Design Review 11.7.18
ccameron, ndonaldson, blyman

C05-01

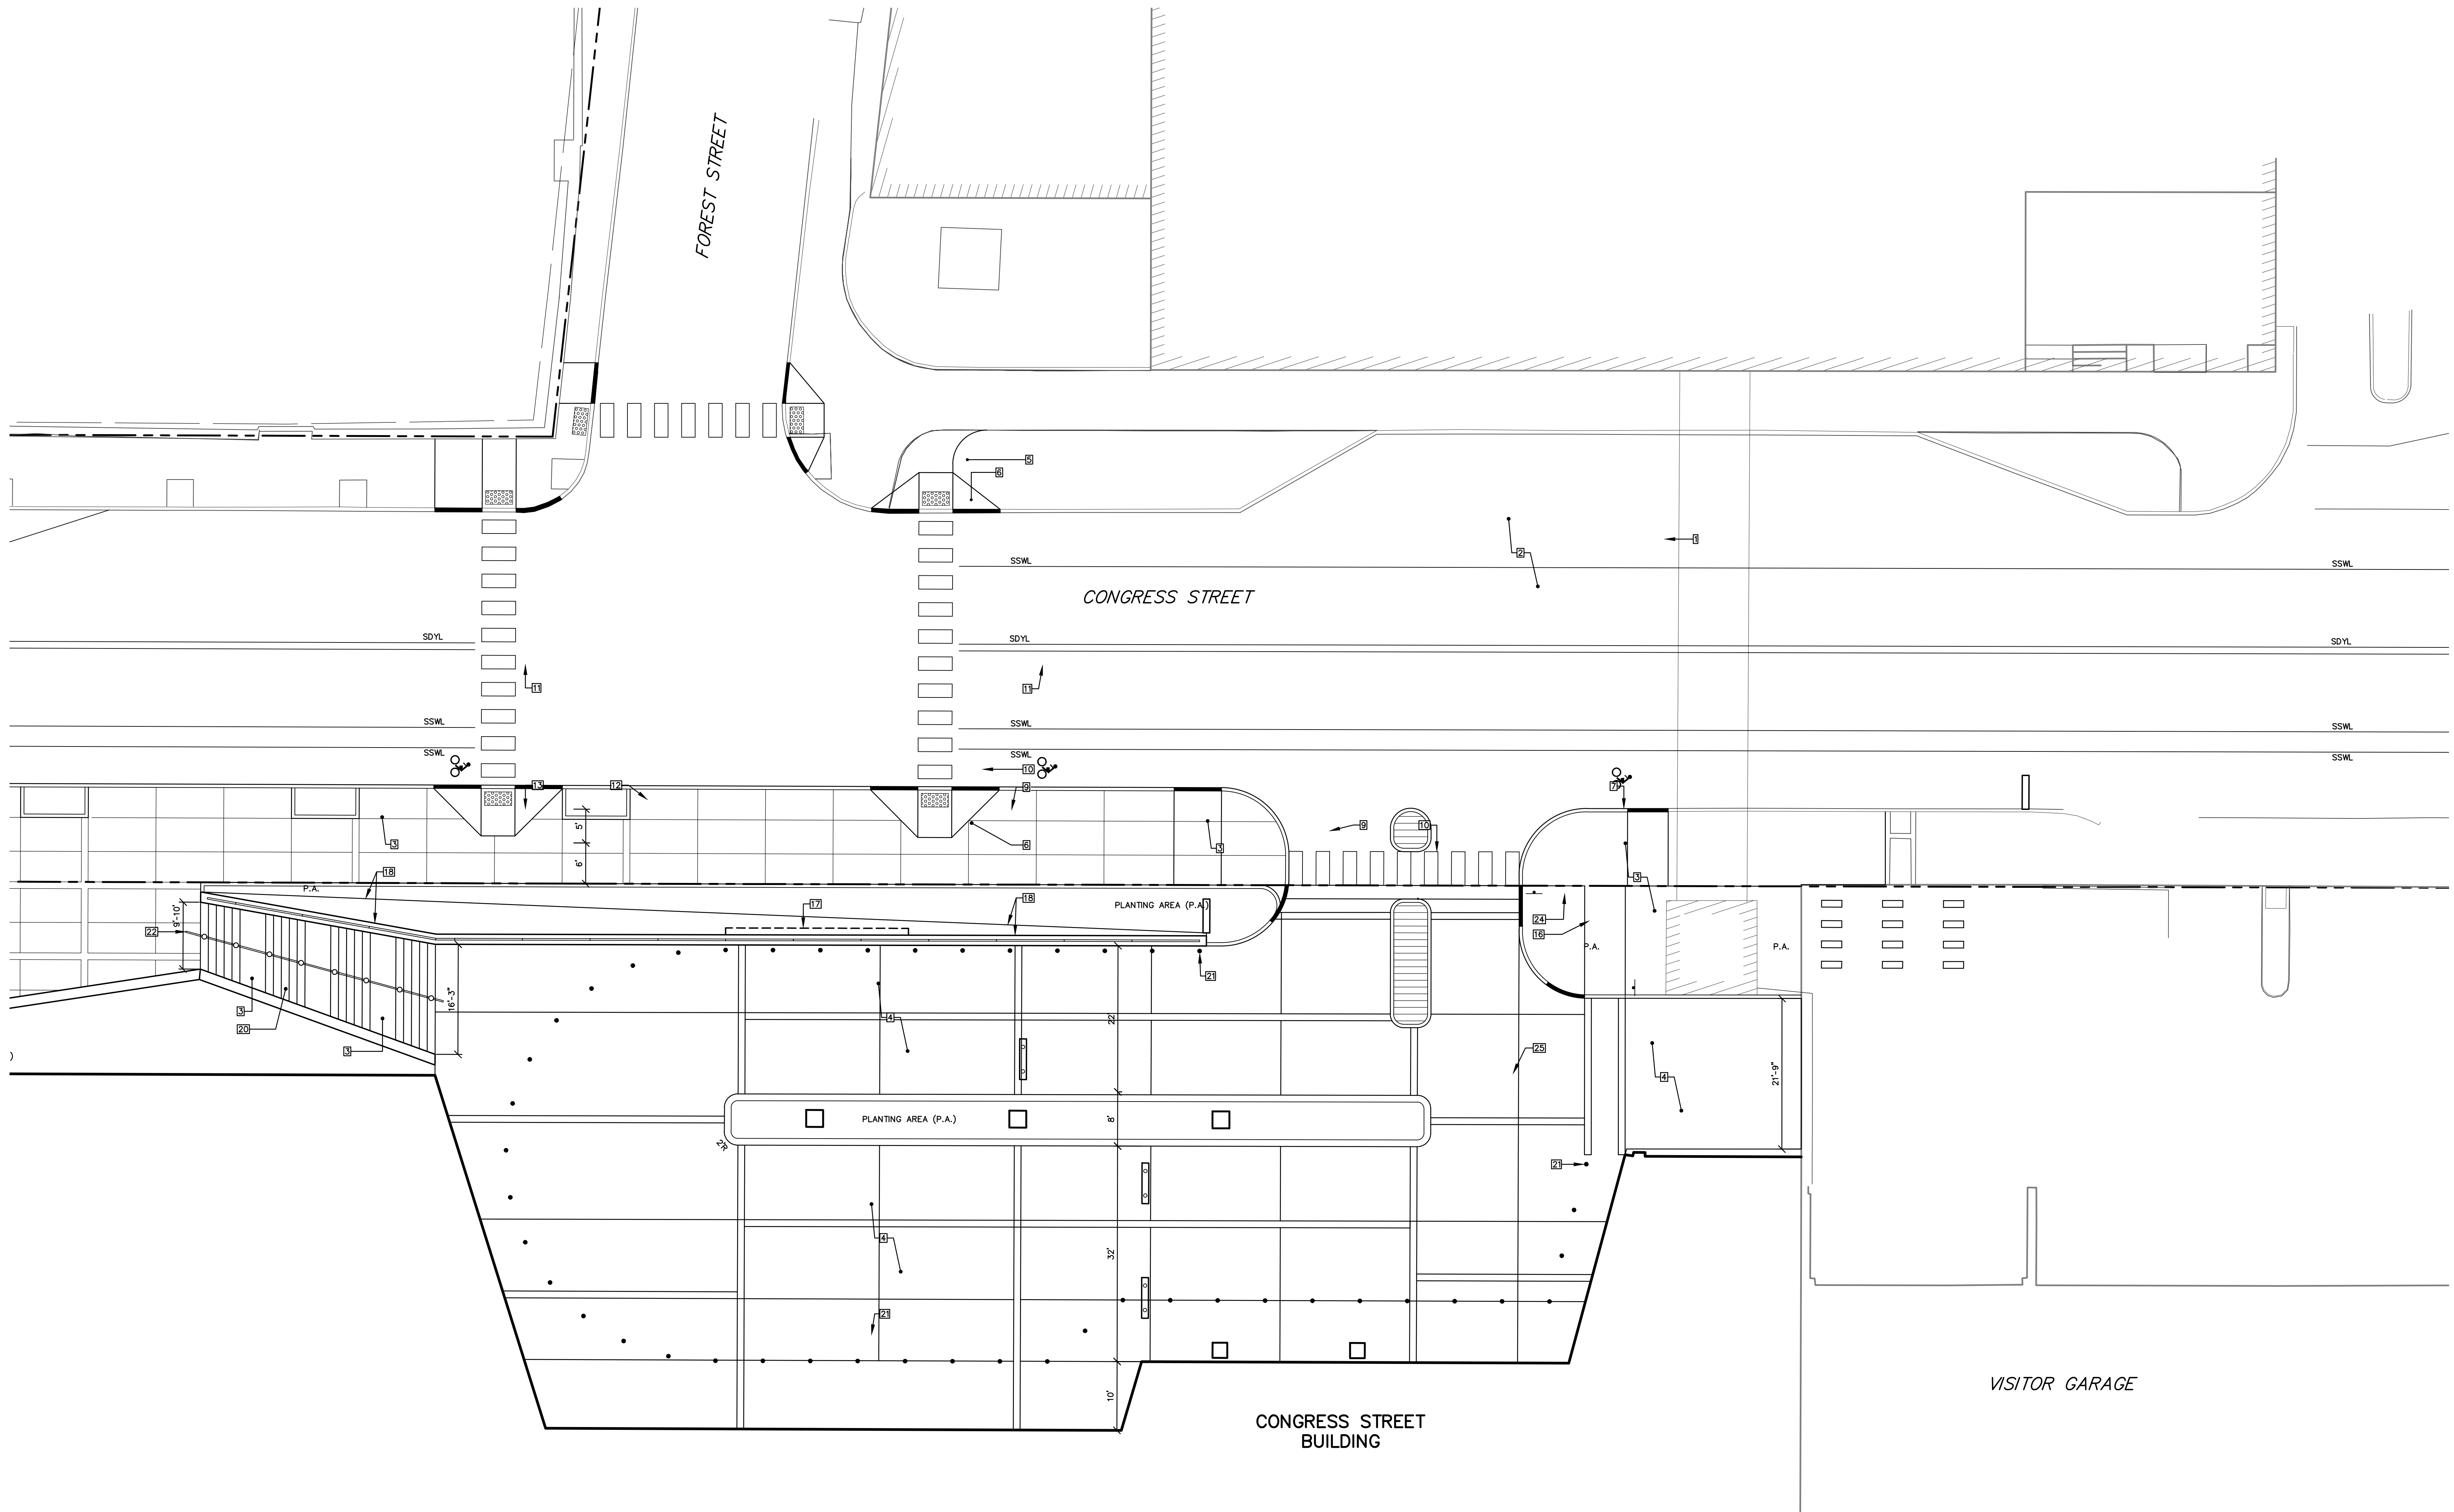
Show street lights in correct location, correct symbol

Show street tree wells of raised granite curb and radius edge per Tech Manual

↳ could do 1 or 2 tree size

Extend concrete to driveway

Remove planting area = hardscape

Add curb edge to planting area

Special paver/color demarking pedestrian cross?

Provide more information about this sidewalk material
↳ color, seams, pattern, scale

Extend sidewalk to next intersection

1 ENLARGED PLAN - C2 GREEN ROOF  
1/8" = 1'-0"

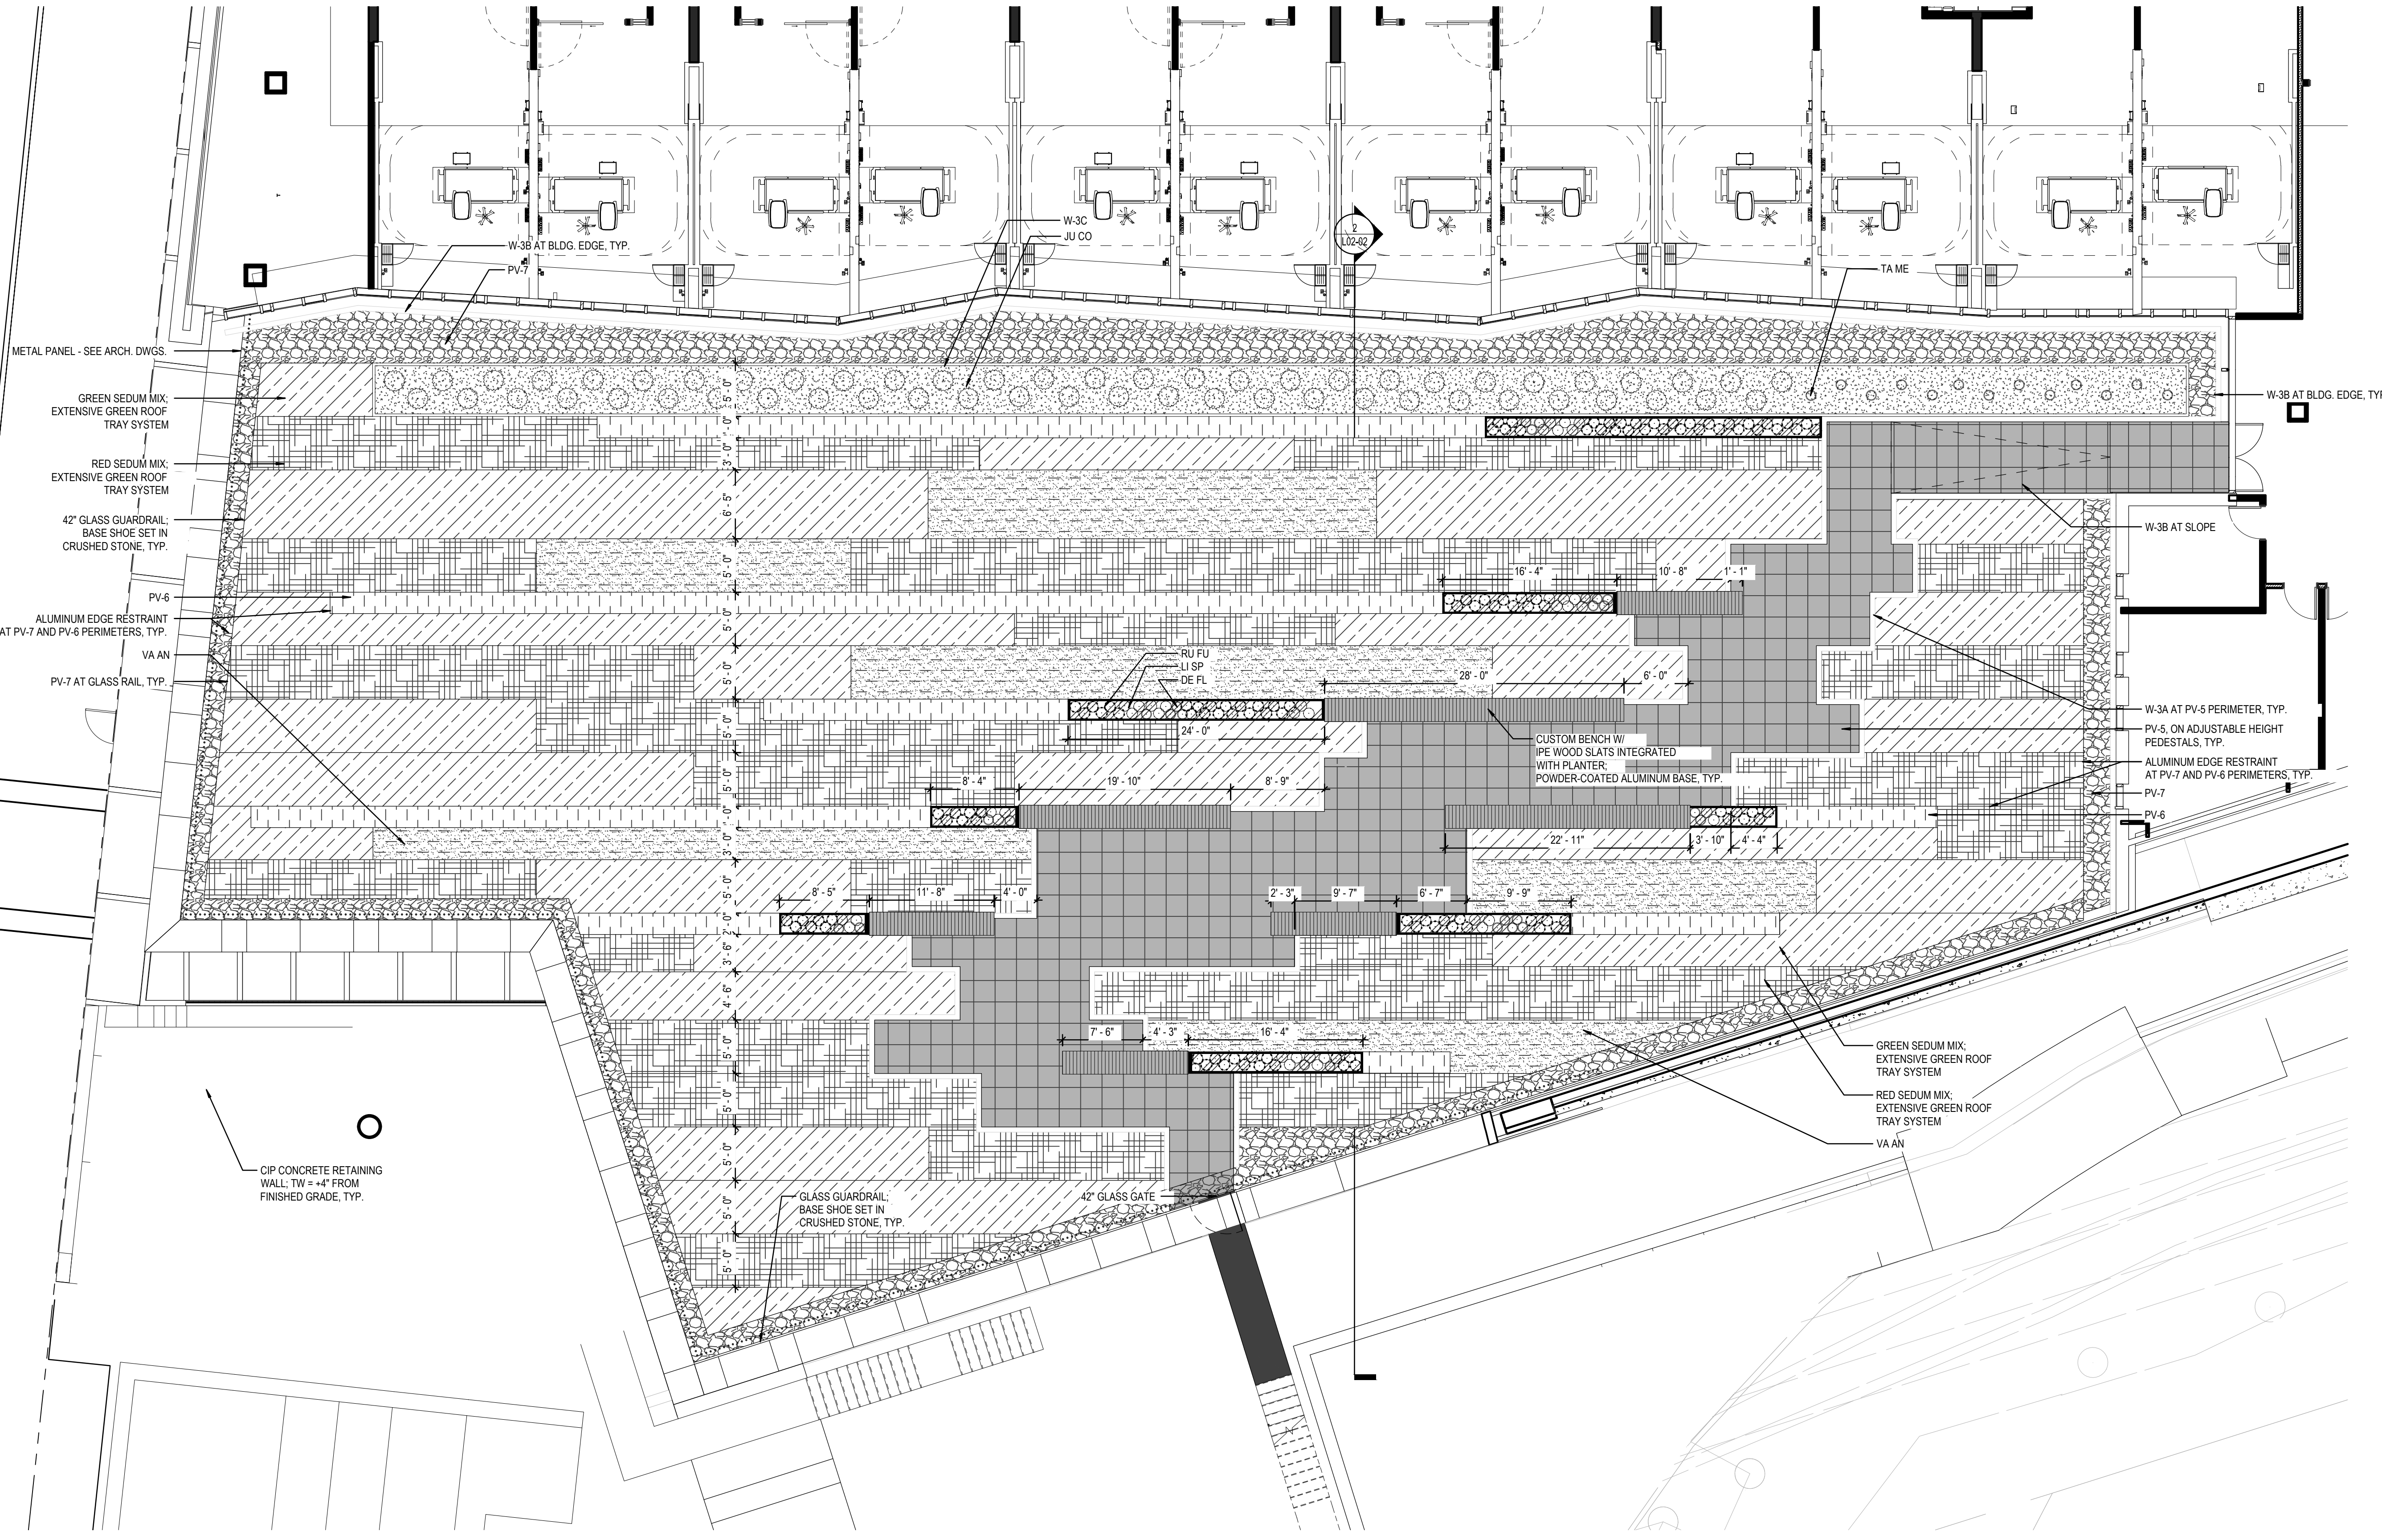
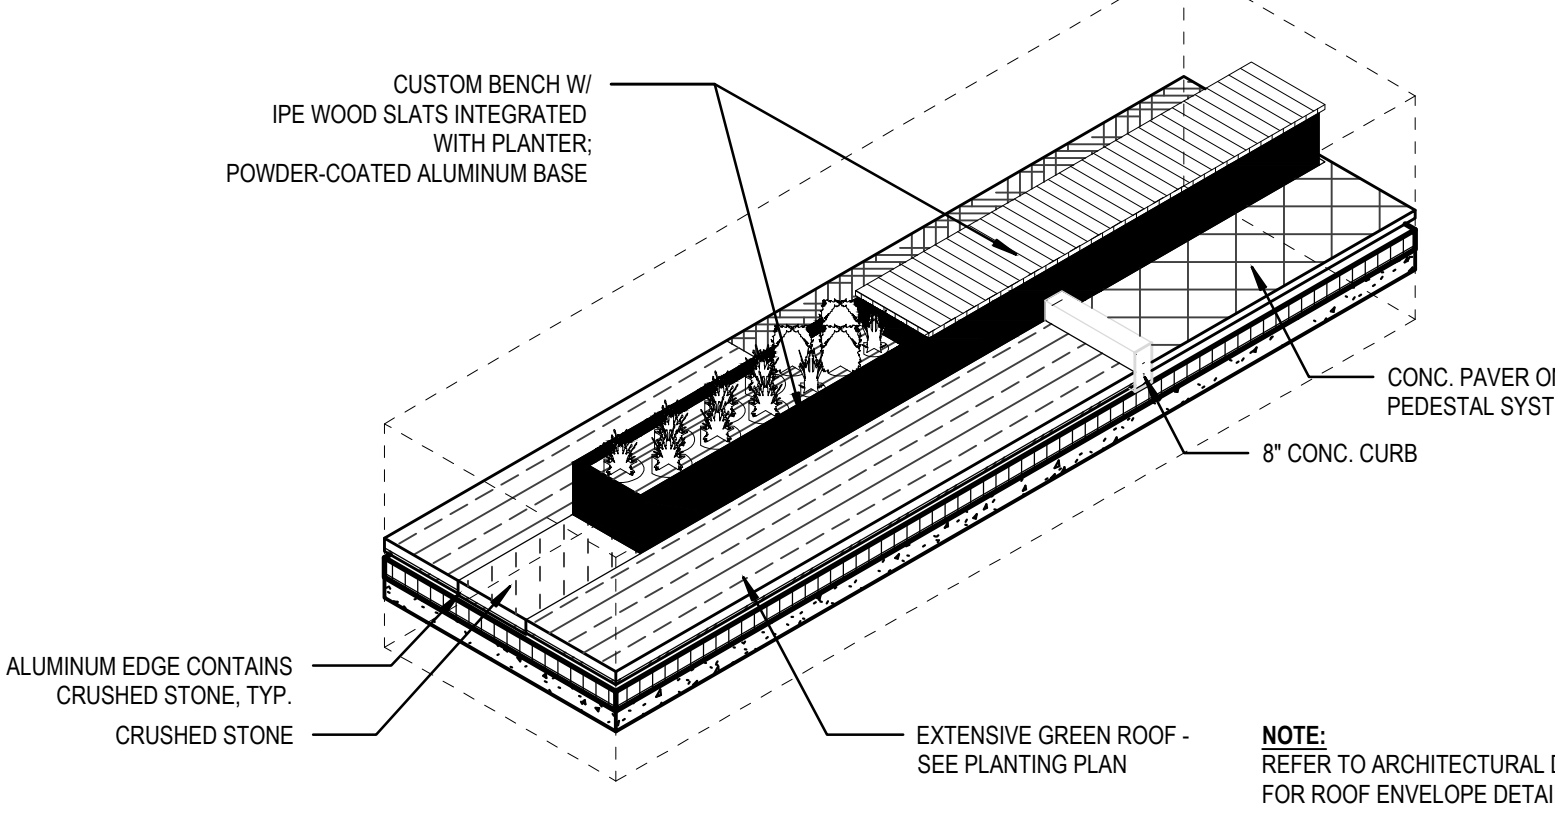
SEE SHEET C05-02 FOR GREEN ROOF
